From: Carol Reynolds
Sent: 03 July 2019 12:15
To: Anita Gardner <Anita.Gardner@arun.gov.uk>
Cc: Planning.Responses <Planning.Responses@arun.gov.uk>
Subject: FW: FG/181/18/PL Workshop, Ferring Country Centre
Importance: High

Environmental Health:

Front Elevation

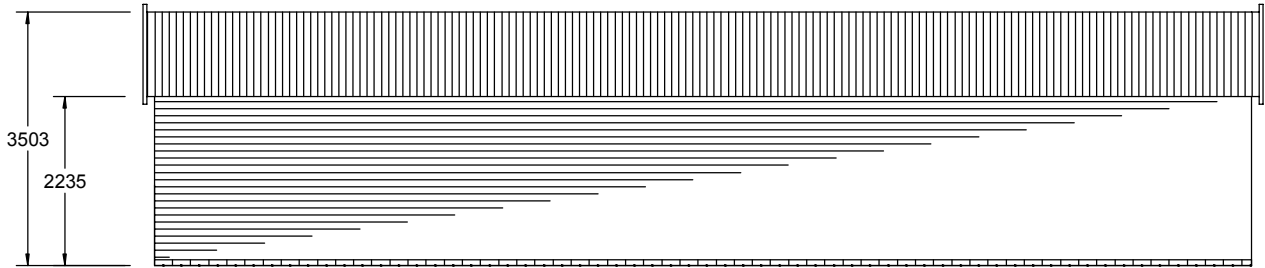
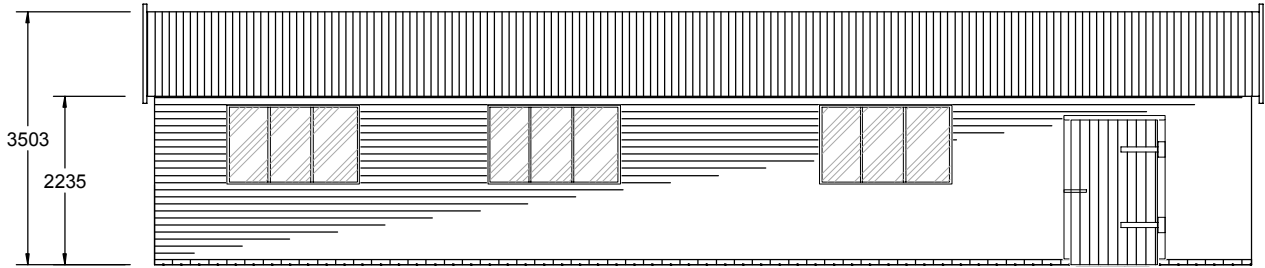
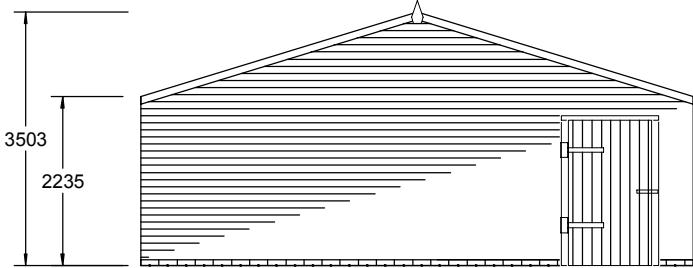
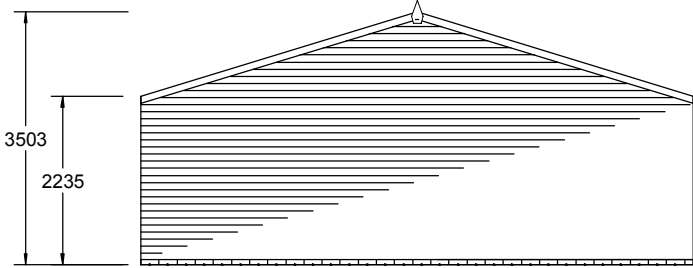
- a. An indicative programme for carrying out the works
- b. Measures to minimise the noise generated by the construction process, including deliveries by the careful selection of plant and machinery and use of noise mitigation barriers.
- d.Detail of any flood lighting, including location, height, type and direction.
- c.Wheel washing facilities
- d. Measures to control the emission of dust and dirt during construction
- e. Any windows and doors provided to this structure shall not open to the east of the site.
